9 October 2018

RE: Section 75W Modification to Project Approval 06_0271
LAND: Lots 1 and 2 DP 800003 (708 Pipers Flat Road, Wallerawang) (Land)

Figure 4 | Site Location and Land Ownership

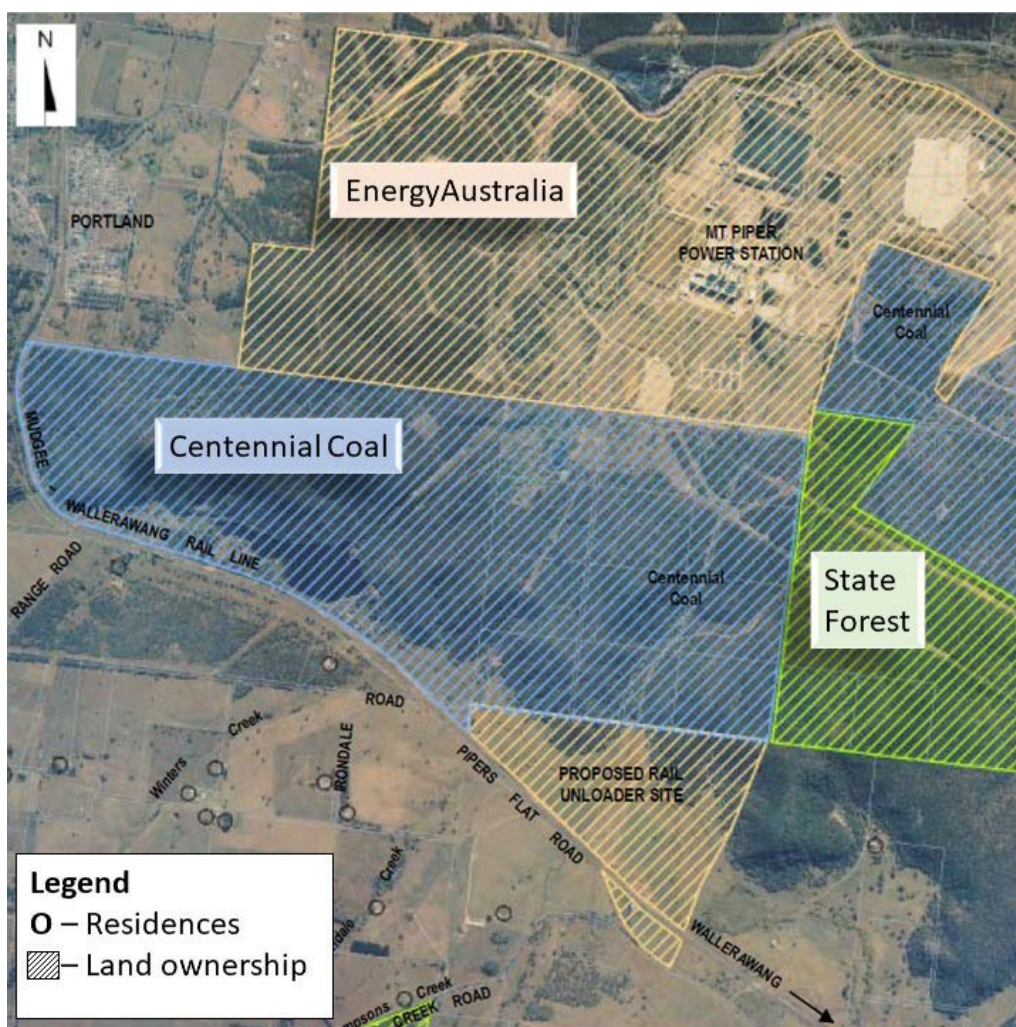
- There is an existing level crossing at the main site access road which is not shown in Figure 4 of EA;
- The pipeline in the original Project is proposed to be installed by way of crossing the rail corridor; and
- Some of bridges, culverts and crossing structures proposed to be installed are within the rail corridor land.
